Re: **Storage Facility**
Project #: PR-2020-004645
Application #: SI-2023-01803

Please find the following responses addressing comments received in a letter dated November, 29 2023. In an effort to address your comments concisely and simplify your review of these development plans, we have summarized your comments and our responses below. Your comment is listed first, followed by the response in Bold.

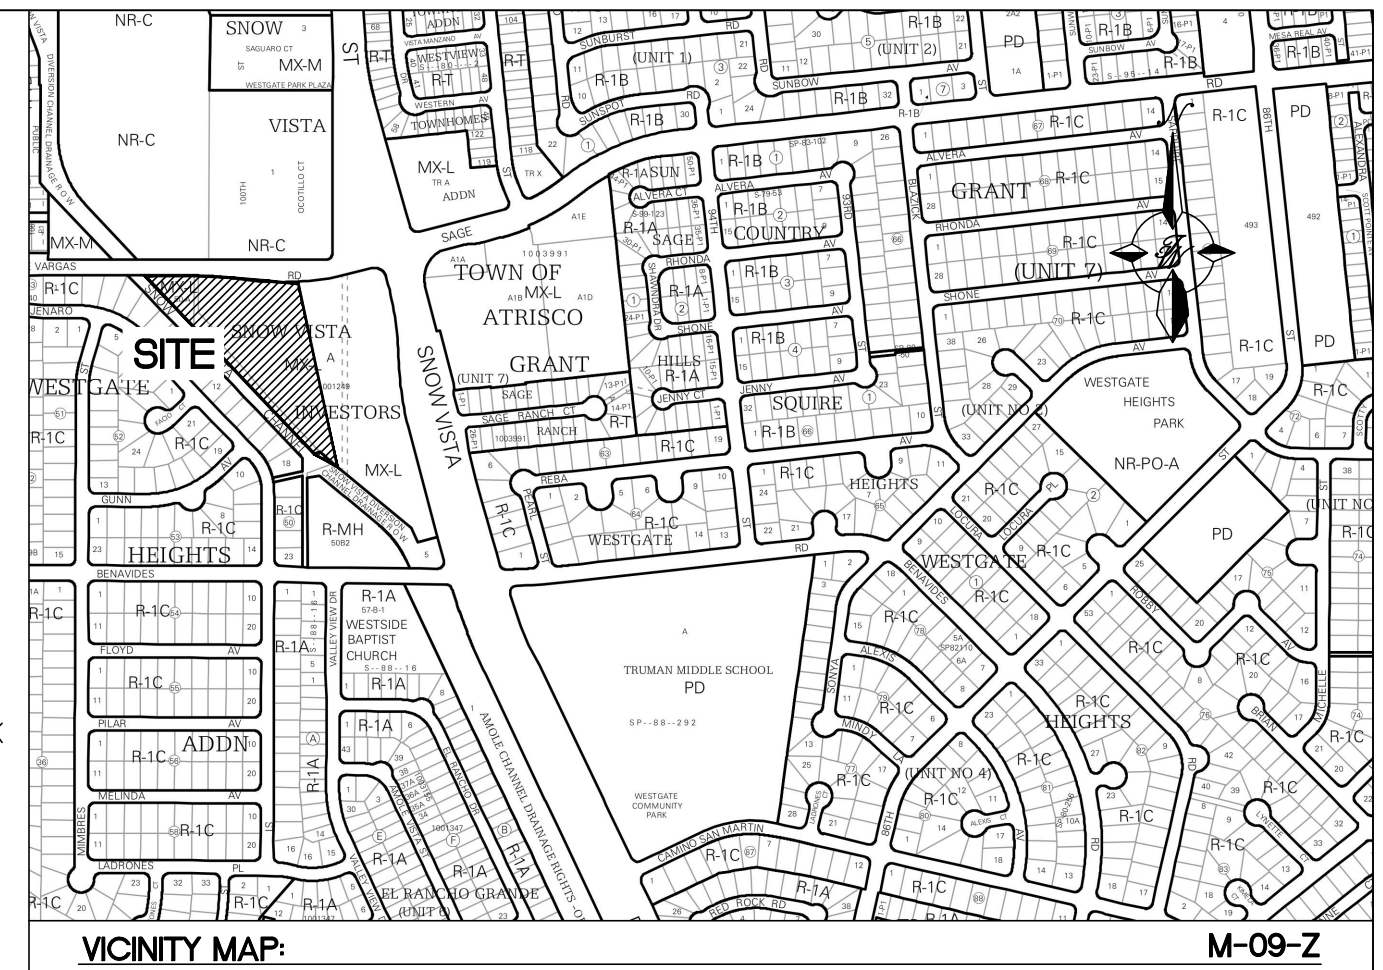
Provide dimensions on building elevation sheet. Provide dimensions at Building 'A' to ensure minimum 5' setback is being provided. Planning staff defers to Code Enforcement regarding setbacks and conformity.

3. *Please note, this storage facility will be restricted to certain hours. Please add a note to the Site Plan indication that public access is prohibited between 10 pm and 7 am: 4-3(D)(29)(d) Within 100

4. **Additionally, please note lighting requirements:* 4 -3(D)(29)(e) Within 200 feet in any direction of any Residential zone district, internal lighting that is visible from the property line shall be dimmed by 50 percent of the maximum foot lamberts allowed pursuant to Subsection 14-16-5-8(D)(6) between 10:00 P.M. and 7:00 A.M.

12. Per 5-5(E) BICYCLE PARKING, 3 spaces or 10% of required off-street parking spaces is required. Please show where bicycle parking is located on Site Plan.

Response: Dimension are shown on elevation sheets. Minimum set back is 5.5' refer site plan.

Response: Note added to "NOTES" section of site plan, note 12.

Response: Note added to "NOTES" section of site plan, note 9.

Response: See site plan keyed note #7.

REVISION	12/07/2023	LN
NOT FOR CONSTRUCTION		
ENGINEER'S SEAL	98TH & SAGE STORAGE ALBUQUERQUE, NM	DRAWN BY BF
	CONCEPT UTILITY PLAN	DATE 10/31/2023
		2023018_MUB
		SHEET # MU-1
5571 MIDWAY PARK PLACE NE ALBUQUERQUE, NM 87109 (505) 858-3100 www.tierrawestllc.com		JOB # 2023018

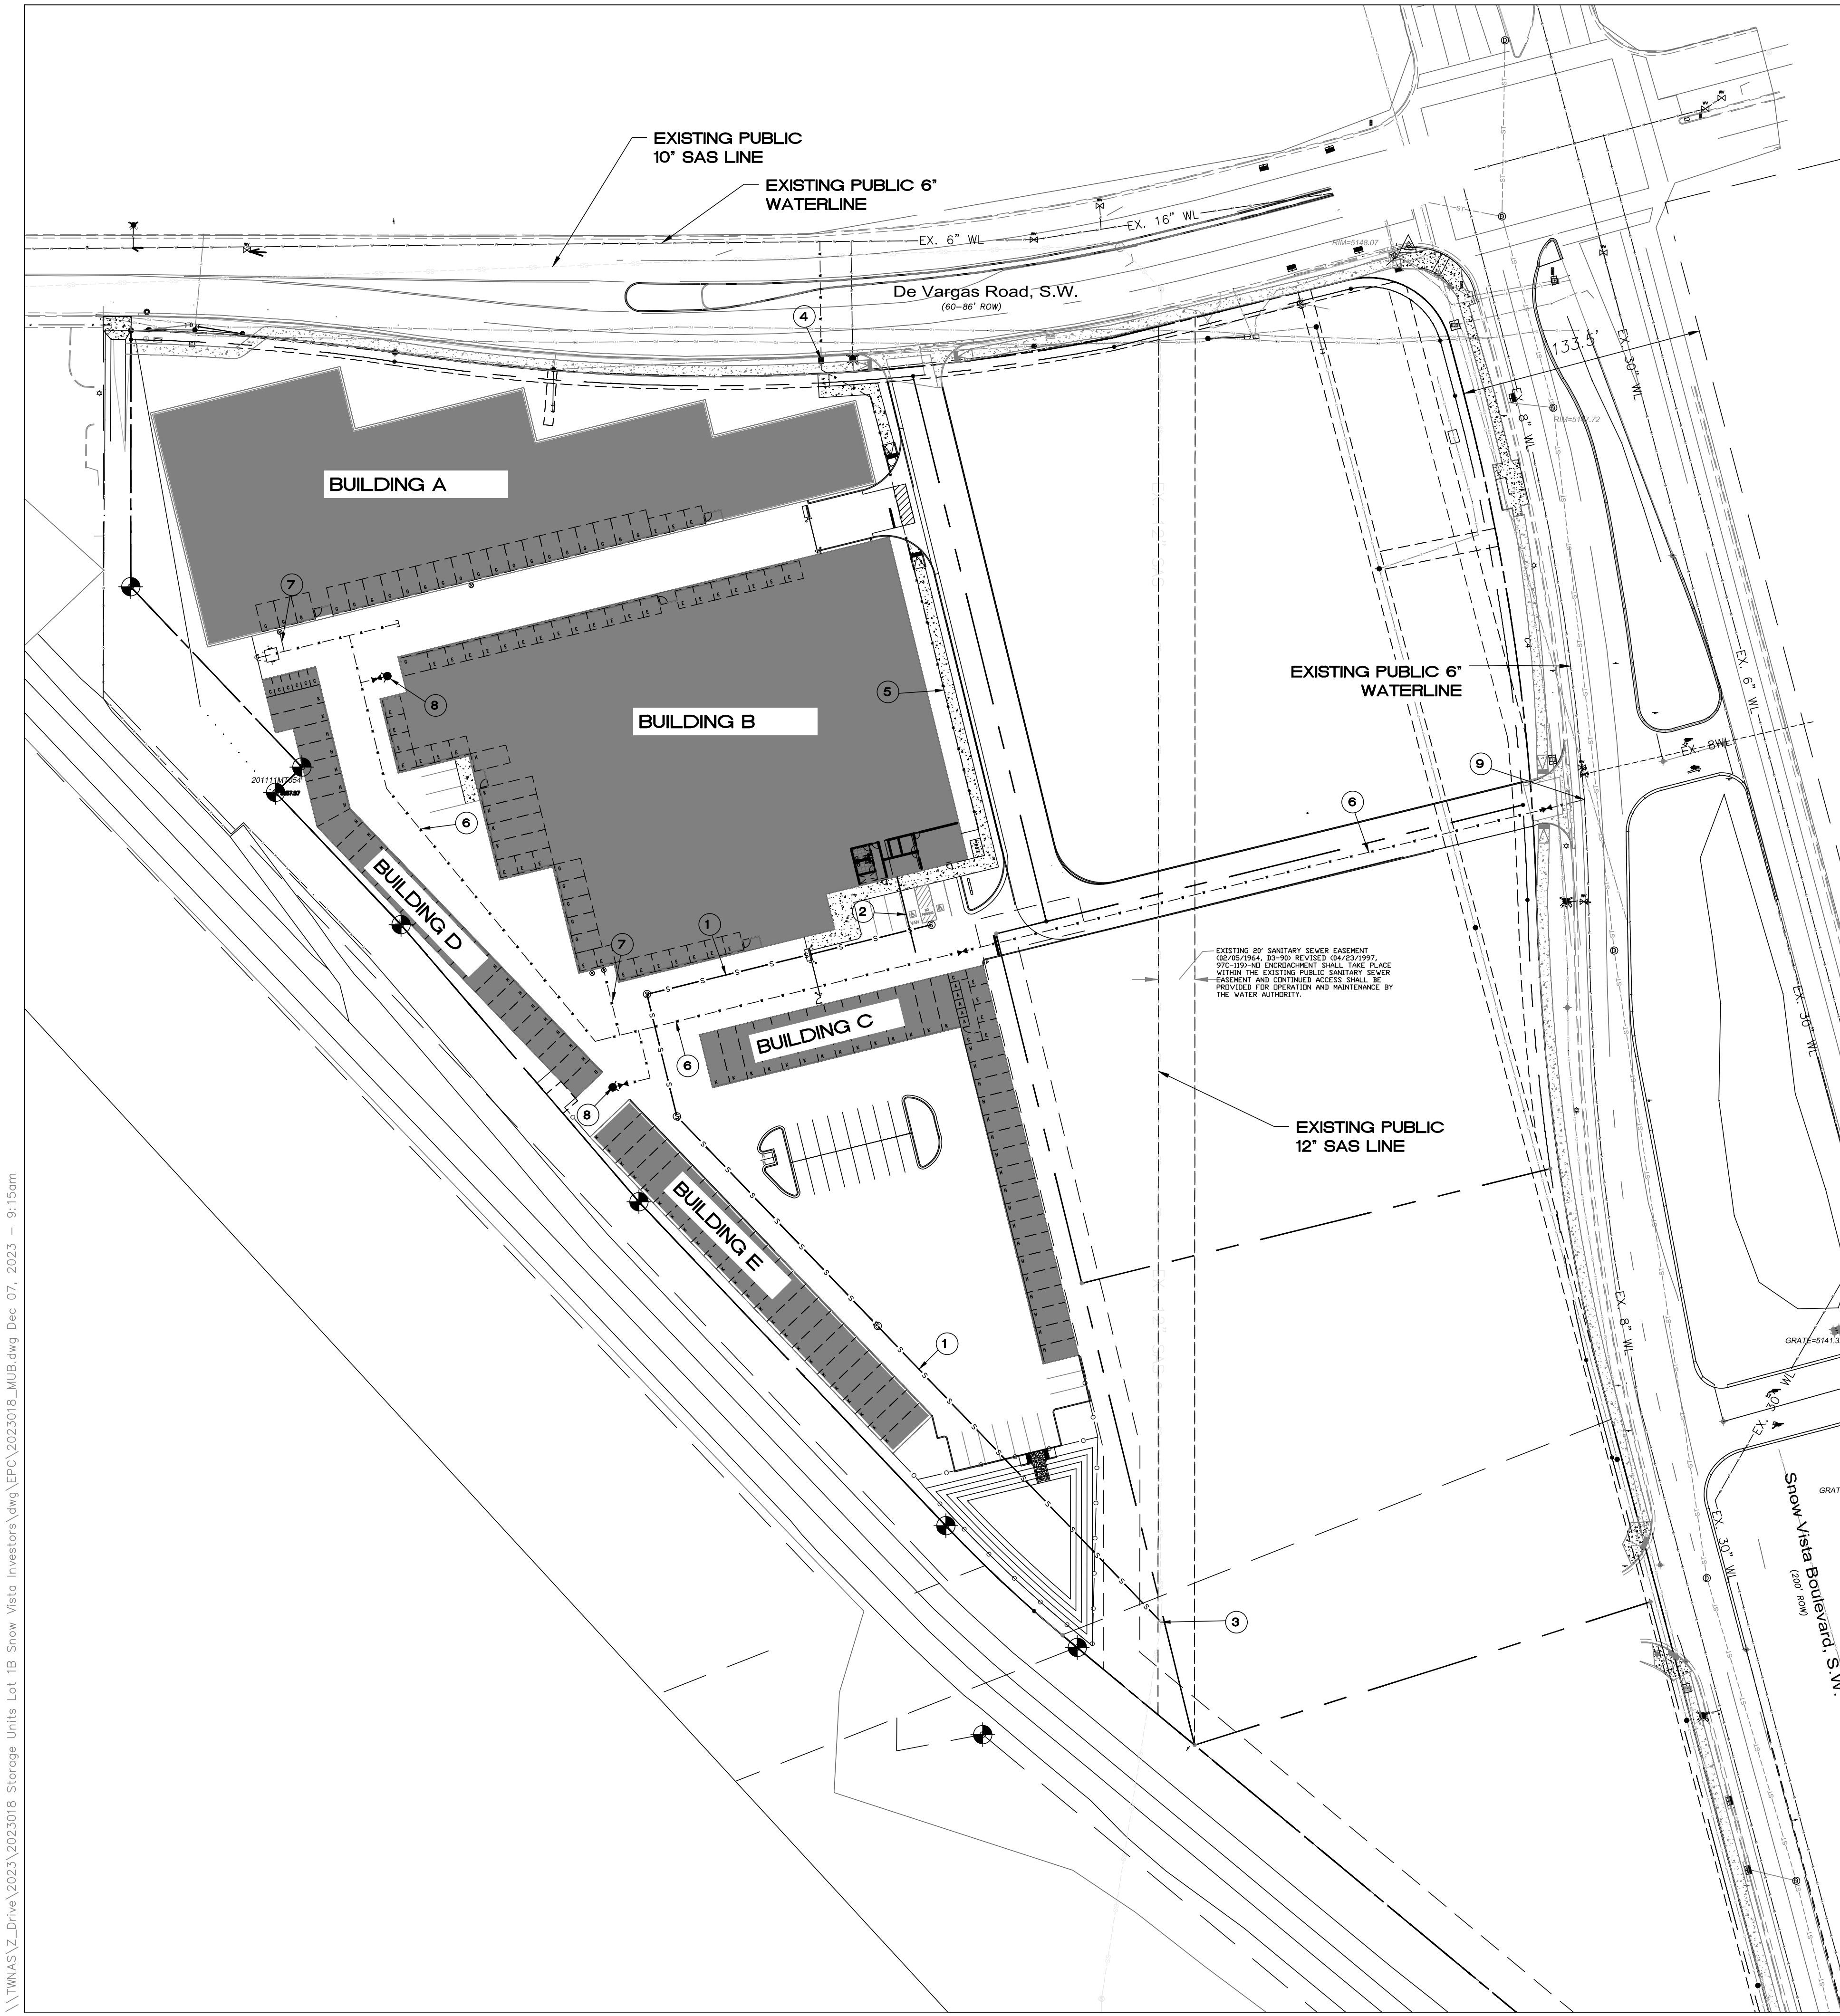
2. Utility Plan:
 - a. Please clearly label public vs. private infrastructure.

- b. Please add the following notes to the Master Utility Plan

i. Coordination with Water Authority Cross Connection Section will be required to ensure proper backflow containment is in place prior to release of meter for the site. Contact the Cross Connection Section at 505-289-3454.

ii. Coordination with the Water Authority Pre-Treatment Engineer is required to ensure the site complies with Water Authority Sewer Use Ordinance. Contact the Pre-Treatment Engineer at 505-289-3439.

c. Please clearly show and label the existing easement for the public sanitary sewer line crossing through the site. Also label this as public.

Response: Existing public lines labeled, proposed on-site infrastructure is labeled as private.

Response: Noted added to Utility Plan.

Response: Easement and label added.

Sheet Title:
Planting Plan
 Sheet Number:
LS-01

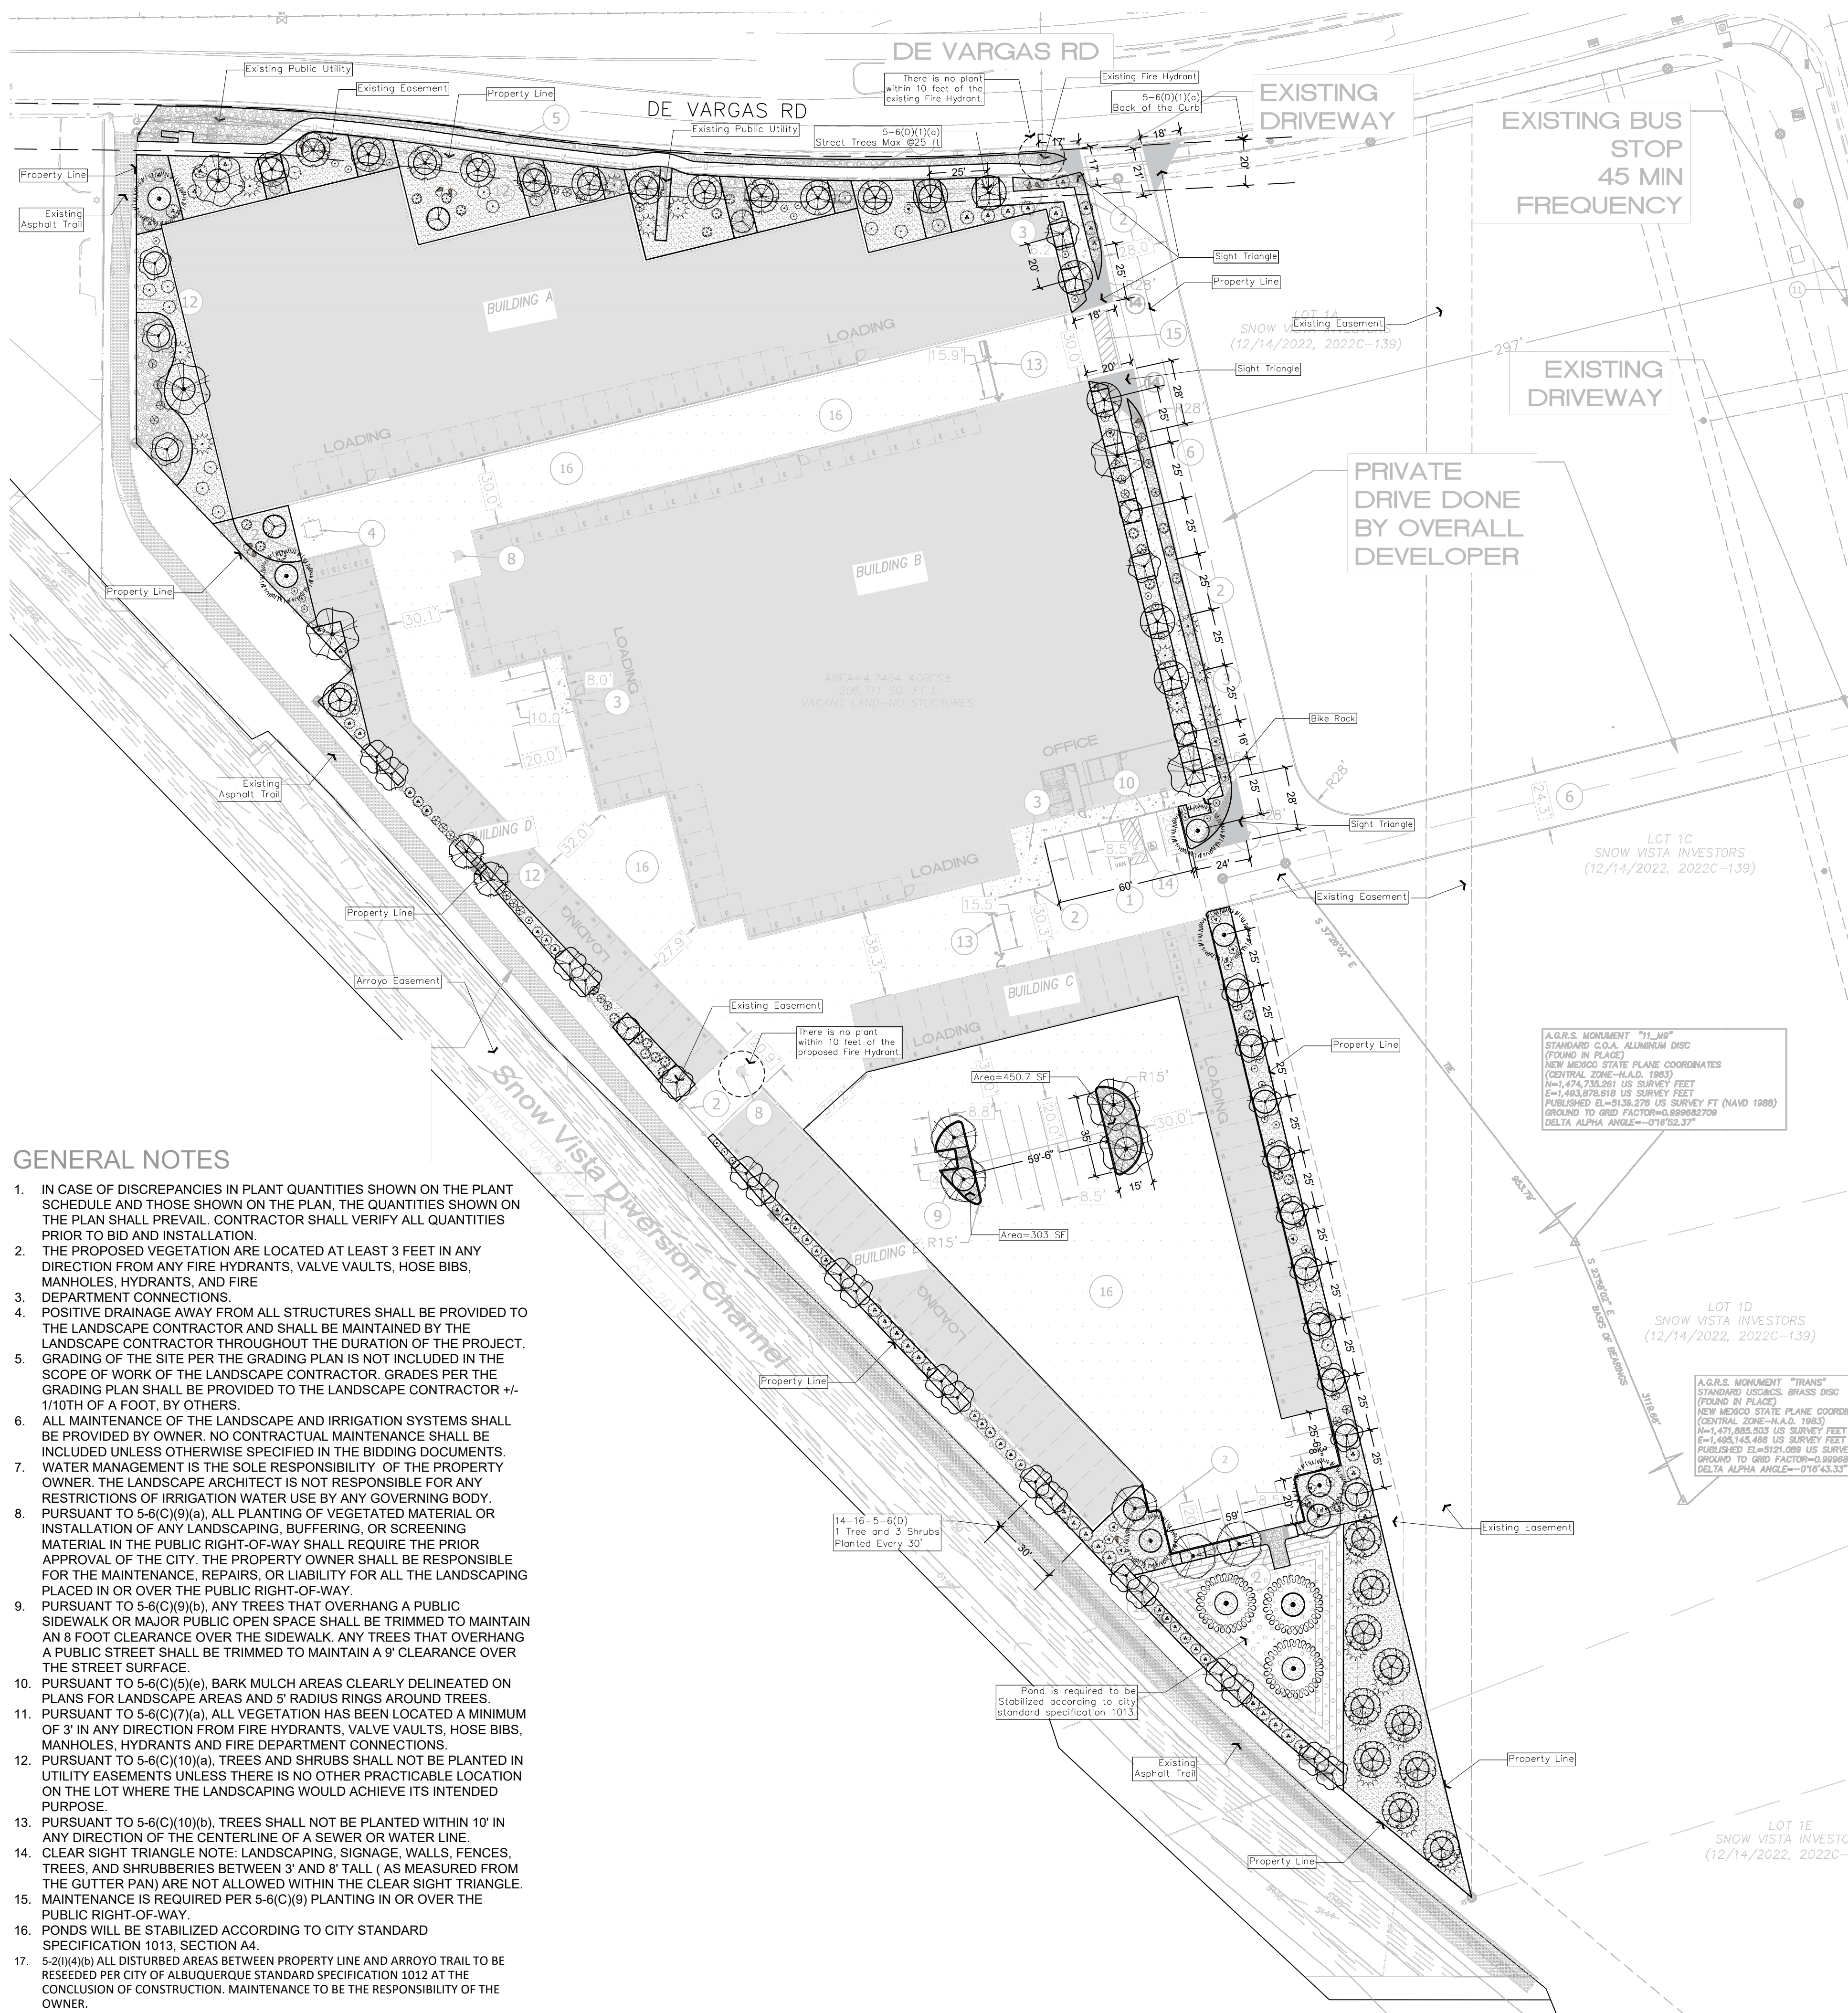
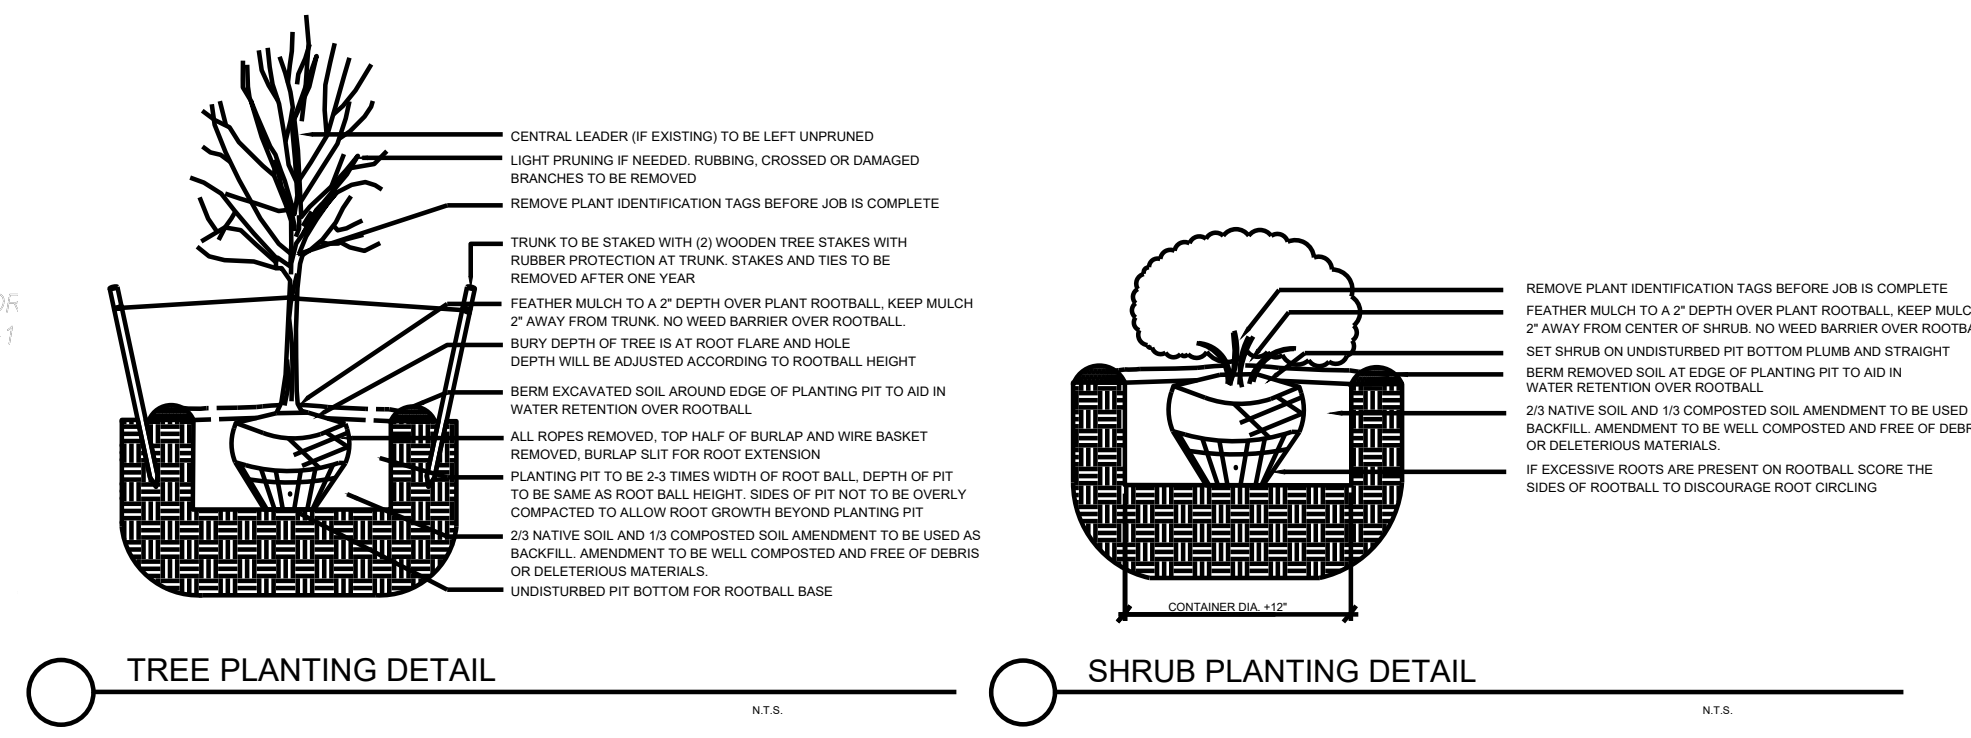
Show dimensions of spacing between trees on walkway on the east side of Building B.

Detail provided on Landscape Plan (LS-01) does not indicate radius of mulch under tree, or what material proposed mulch is. Proposed mulch must be organic material. Please see below:

Incorporate stormwater management areas on the Landscape Plan (LS-01). A ponding area is being proposed at the south side of the subject property. Refer to City of Albuquerque Specifications Section 1013 Slope Stabilization and seeding for landscape requirements at ponding area. Drainage Ponds Slope Stabilization and Seeding Requirements.pdf (cabq.gov) Add a note to the Infrastructure list that ponds will be stabilized according to City Standard Specification 1013.

Provide landscape calculations to ensure this requirement is being met.

Provide dimensions to ensure this requirement is being met.

Show calculations to ensure this requirement is being met.

Provide square footage of tree planters provided for parking lot landscape requirements to ensure this requirement is being met.

Response: Tree spacing along pedestrian path east of building B is now shown on LS-01.

Response: Plant and material legend on LS-01 has been updated to indicate the required mulch ring.

Response: Ponding area now incorporated into landscape plan. Slope stabilization and seeding noted on plan material legend and Note 16, General Notes.

Response: Additional landscaping now included in interior parking on the plan and included in Landscape Data calculations to meet this requirement as well as note 21 below. Please note, parking lot landscape islands were previously shown only as striped asphalt. Civil plans will need to be adjusted accordingly.

Response: New landscape areas added in parking lot interior and dimensions shown.

Response: Calculation added to LS-01 landscape data.

Response: Calculation added to LS-01 landscape data.
